Re: EXHIBITION OF STATE SIGNIFICANT DEVELOPMENT APPLICATION SSD-8586218-MOD-1

PROPOSAL:	TEMPERATURE CONTROLLED WAREHOUSE FACILITY
ADDRESS:	LOT 4, BRINGELLY ROAD BUSINESS HUB, LEPPINGTON (LOT 11 DP 29104)

TITLE				
SITE PLAN				
DATE	SCALE	PROJECT NO.	DWG NO.	REVISION
03/02/2021	1 : 500 @ A1	20245	DA101	F

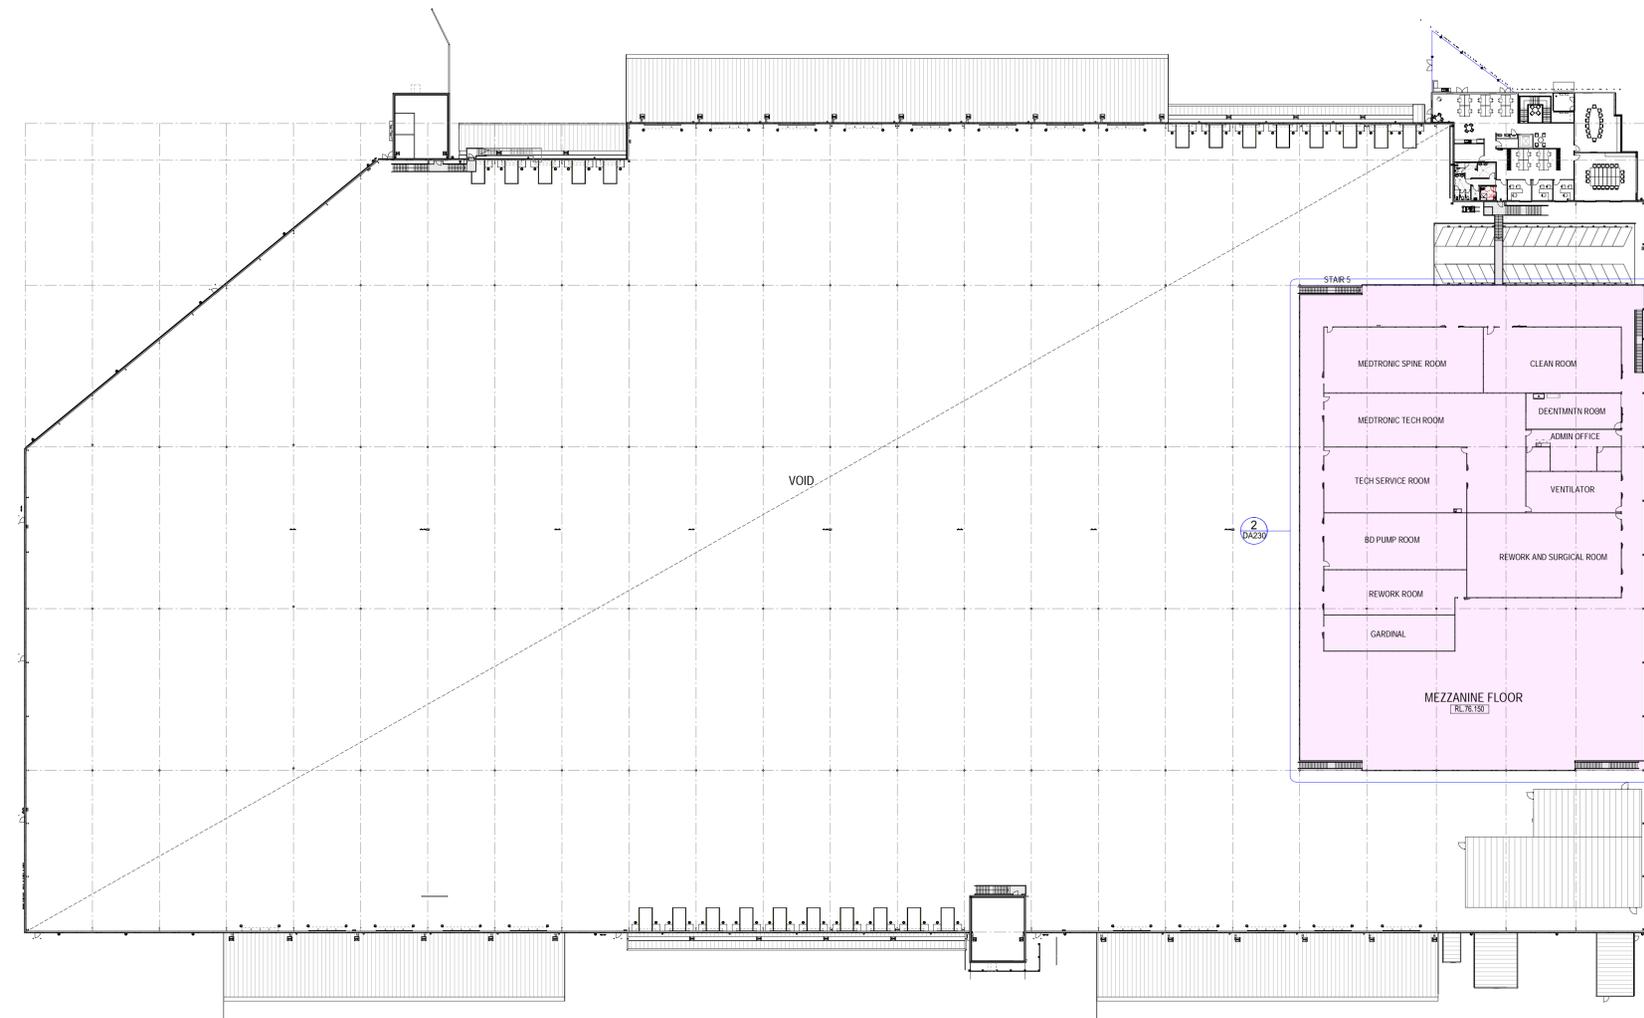
2. As part of their assessment, SLR Consulting Australia Pty Ltd focused on potential noise impacts associated with the use of refrigerated trucks in the south-west loading docks. The Site Plan (Project No. 20245, Dwg No. DA101, Revision F) prepared by SBA Architects dated 3rd February 2021 confirms that the proposed modifications include a freezer and cool room. In addition, the aforementioned floor plan identifies additional 'plant' in the external grounds of the premises. It is anticipated that the coolroom and freezer will include refrigeration motors or similar equipment which may contribute to noise emissions from the site.

The assessment shall be representative of all noise generating activities on-site including but not limited to mechanical plant. In this regard, the cumulative effect of noise must be considered when assessing the impact upon receivers.
